Our Ref: 24/01083/HFUL
Your Ref: 15 Kelvin Close, Cambridge

Cambridge City Council Application for Planning Permission

Proposal: Single storey rear extension, new gate, side panel and canopy to side of house, external wall insulation and render to side and rear of house

Site address: 15 Kelvin Close Cambridge Cambridgeshire CB1 8DN

Drawing No: 1114-309  
Scale: 1:100 @A4  
rev date: 4 April 2024  
ver: 2  
Project: 52, Kelvin Close,  
Cambridge

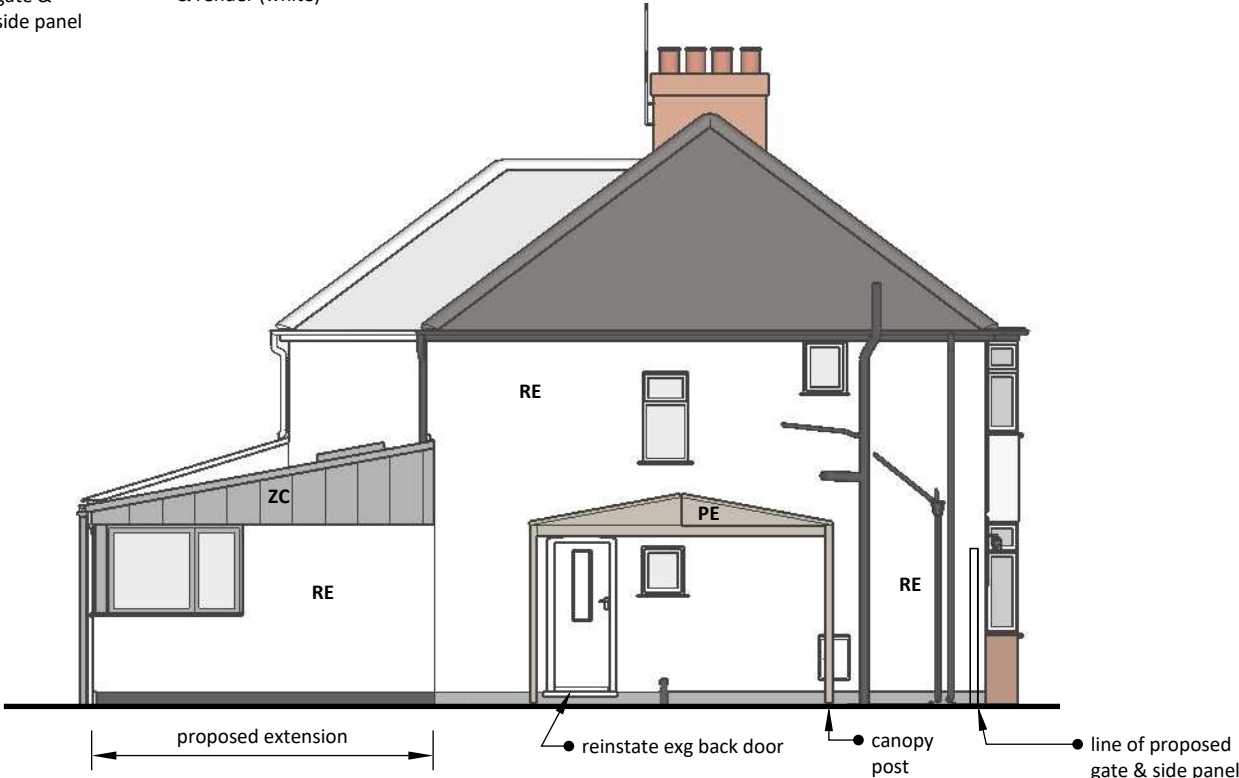
1. Please provide proposed elevations. Please ensure these are at a scale of 1:50/1:100 and show materials, style and finish.

Drawing No : 1114- 309, this proposed elevations drawing now showing the new side panel and new the gate.
